RE: Abundant Life Gymnasium
2851 Arenal Rd SW
Revised Grading and Drainage Plan
Engineers Stamp Date 4/12/16 (M10D076)

ABUNDANT LIFE GYMNASIUM

Updated Grading and Drainage Plan (M10-D0006)

E
C-2.0

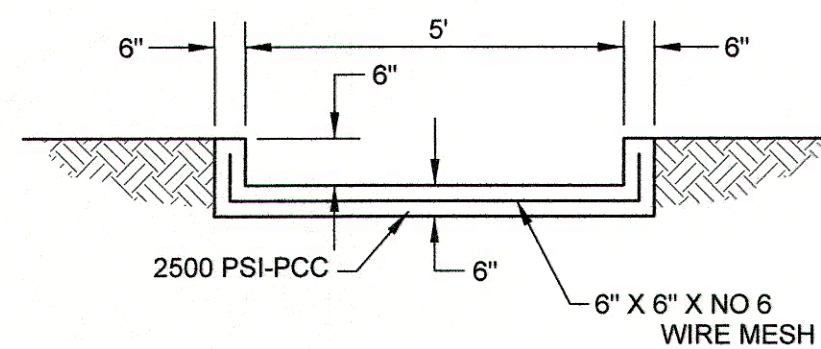
- 6. The overflow spillway at the beginning of the channel is 88.0, but the end of the channel is 88.40 which is higher. Revise the spot elevations.
- 7. Provide more spot elevations for the swale on the east in the existing parking. Will storm water be able to drain out of that area?

- 6. The overflow elevation of the spillway is 88.50 vs. 88.40 at the accepting asphalt.
- 7. The plan illustrates all spot elevations reported on the topographic survey. I have visited the site and verified that positive drainage exists in this area.

J
C-2.0

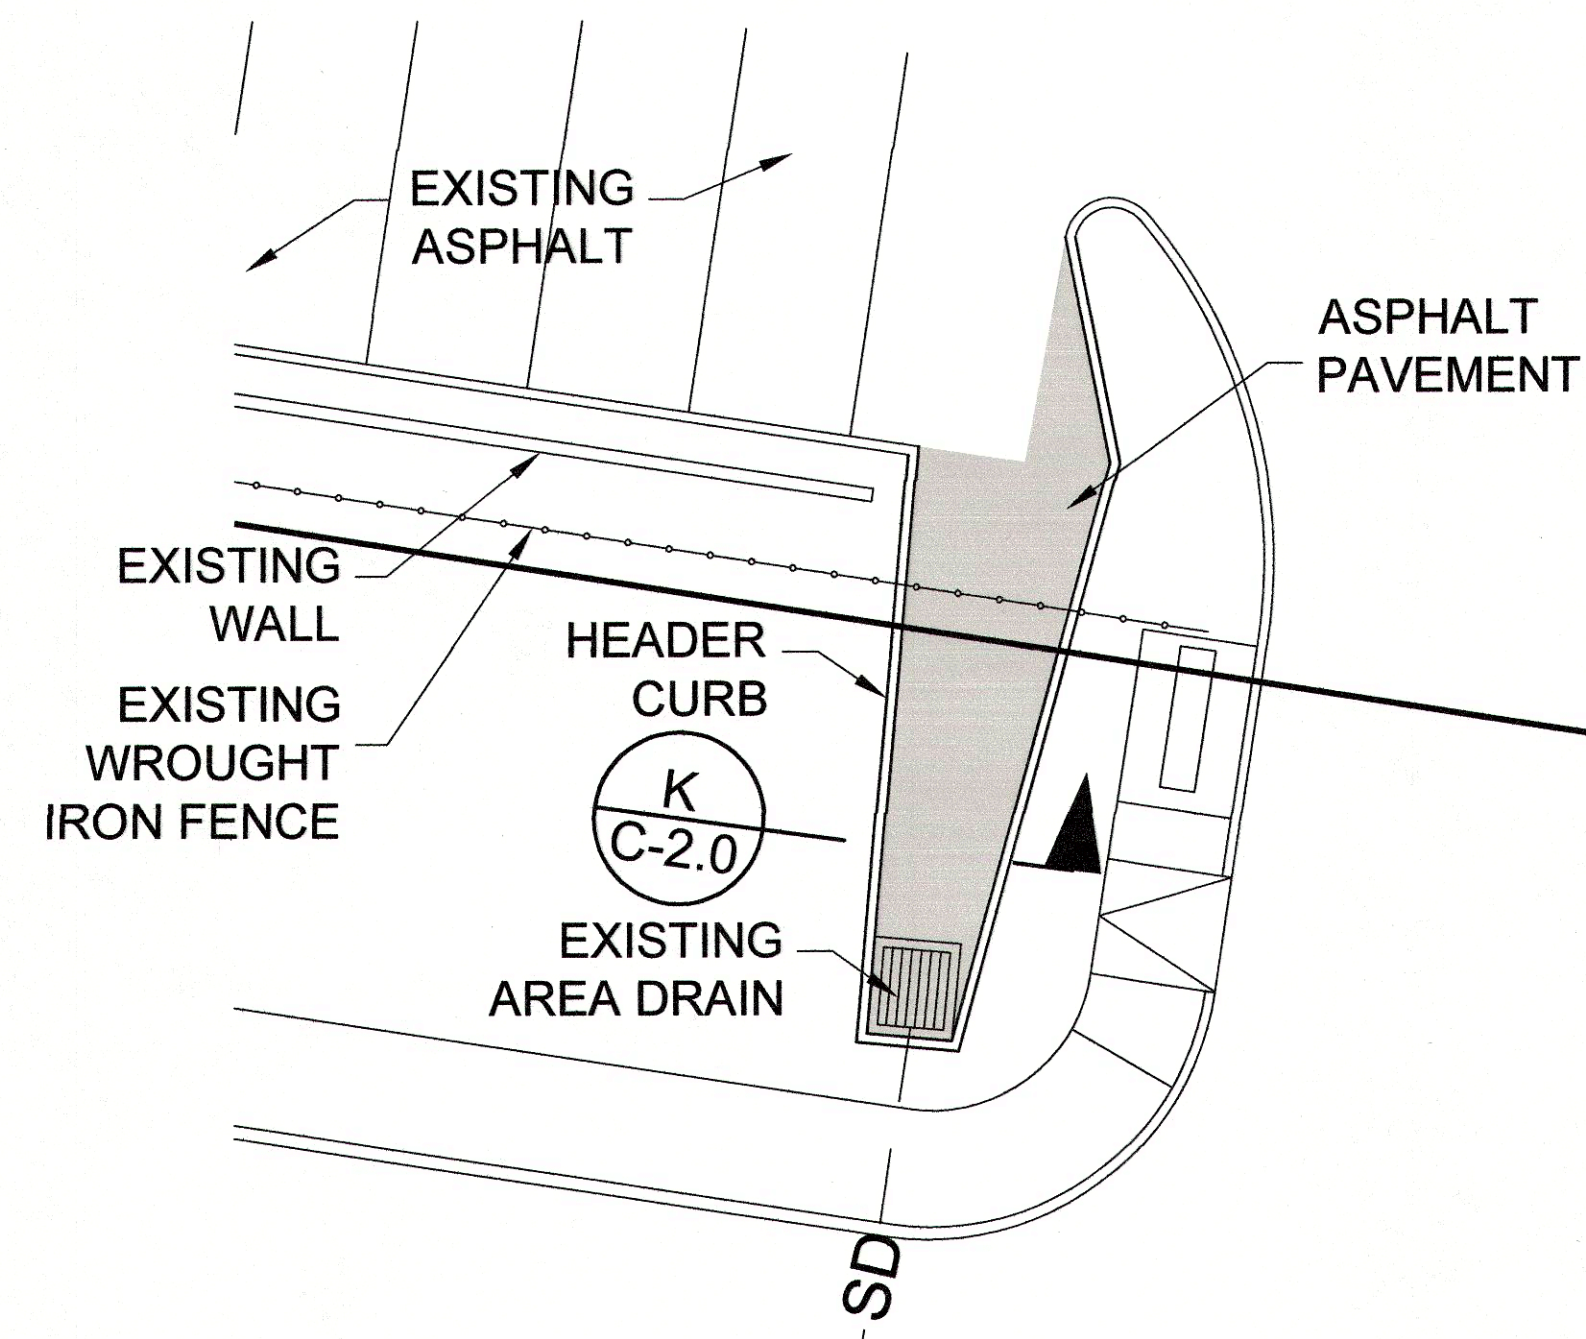
- 2. When requesting SO-19 approval, provide two sets of paper copies of the plans.
- 3. For Detail J/C2.0, what are the various width and length dimensions of the channel?

- 2. Two (2) copies of the plan are provided for SO 19 purposes.
- 3. Detail J/C2.0 has been revised to include a stormceptor manhole that will capture oils and trash as required by Bernalillo County.
